2025/0493

29 Uplands Avenue, Kexborough, Barnsley

Erection of a two storey rear extension.

PROPOSED REAR ELEVATION
SCALE 1/100

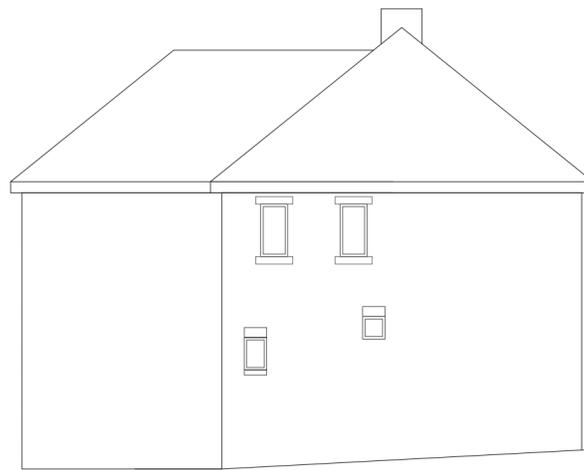
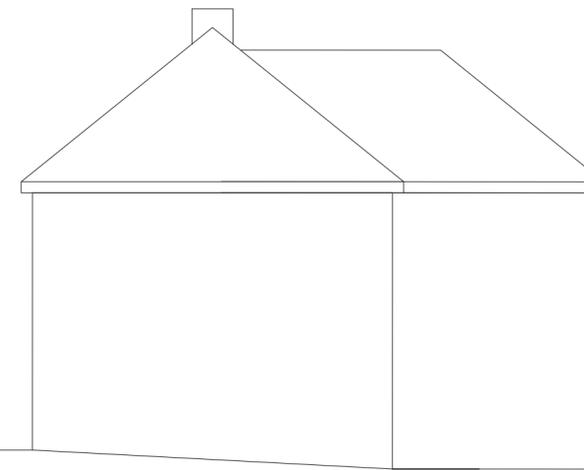
There will be no significantly harmful impact to visual amenity or character of the area. The proposal complies with the SPD which requires two storey extensions on semi-detached properties to extend maximum of 3.5m and set down from the ridge.

The windows rear face directly over the applicants own garden area and beyond that is the very bottom of another garden. The distances between exceed the requirements set out in the SPD and therefore it is not considered the proposal would introduce harmful overlooking.

PROPOSED GROUND FLOOR PLAN

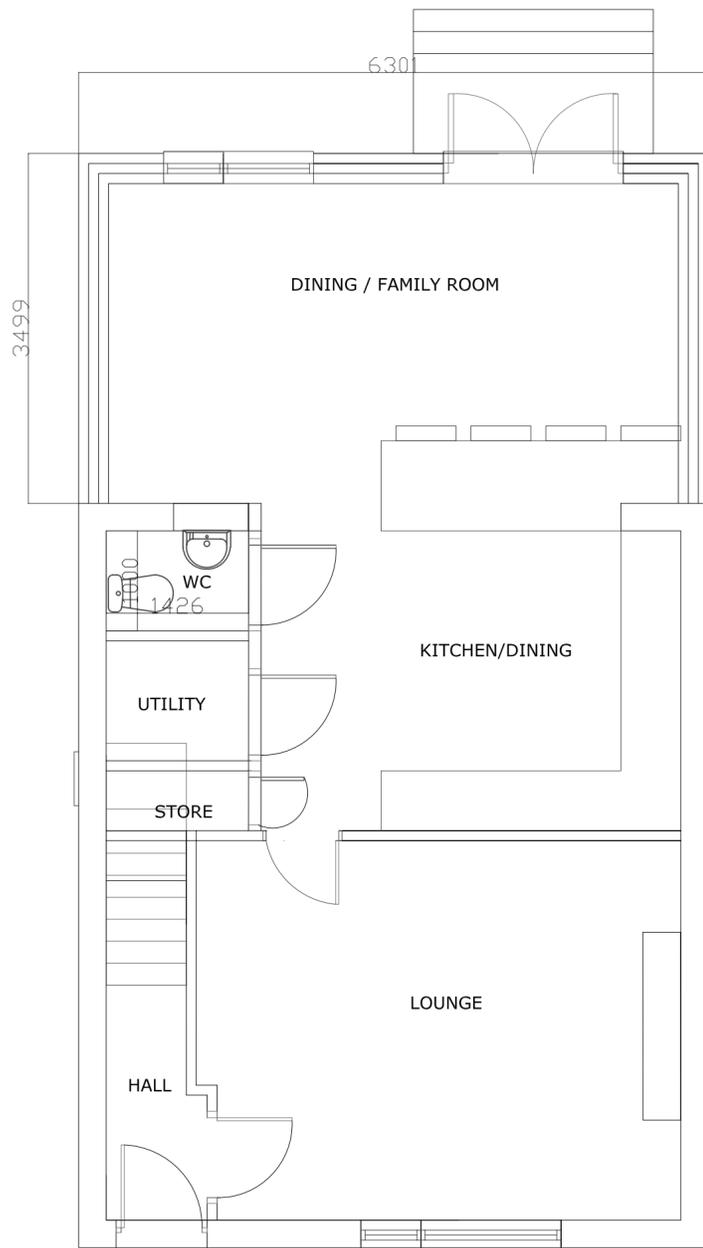
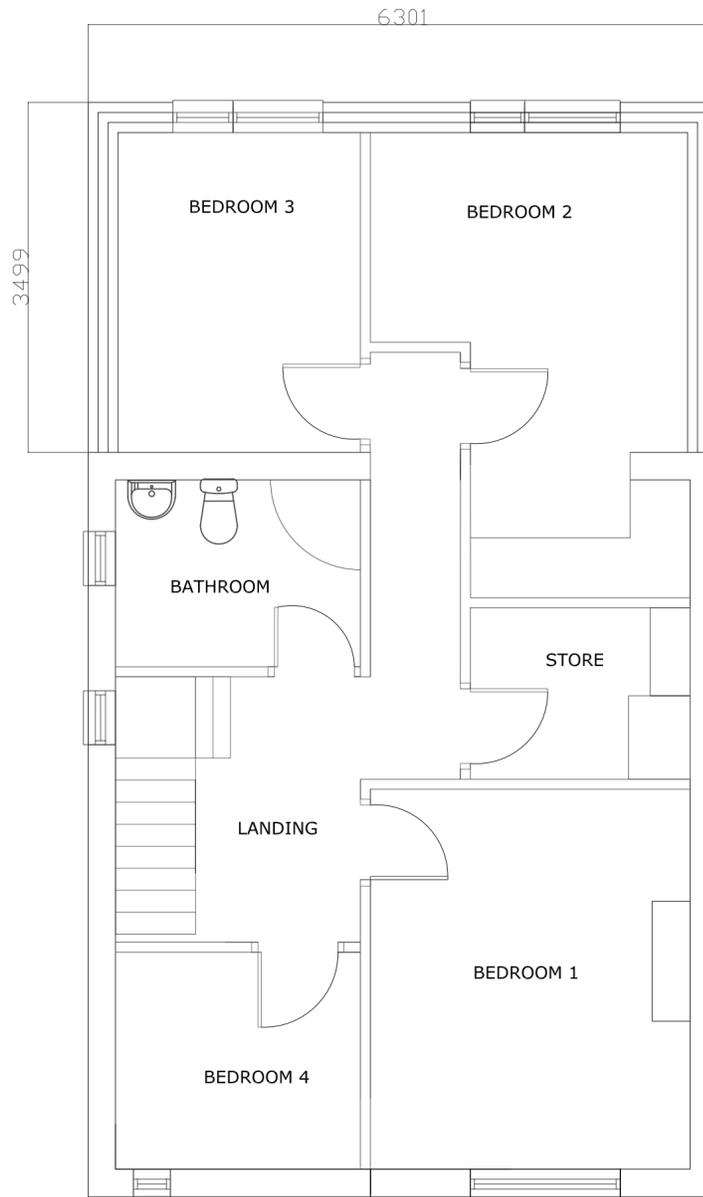
The application site is located within a residential area and is allocated as Urban Fabric. The immediate surrounding area features predominantly residential properties. The proposed development is to erect a two storey extension to the rear of the property which will create an enlarged dining/family space at ground floor with two additional bedrooms above.

There will be no significantly detrimental impact upon residential amenity. Given the positioning of the extension on the east side of the adjoining neighbour, some minor overshadowing may occur, however this is likely to be early morning only and not for a substantial part of the day. The neighbour also has a single storey extension/conservatory which extends slightly beyond the proposed extension, meaning the only slight loss of light may be to the upstairs windows and the conservatory will still benefit from getting direct sunlight for the majority of the day. On balance, the local planning authority consider this to be acceptable and conclude the proposal is unlikely to cause would harm neighbour amenity by virtue of overshadowing or loss of light.
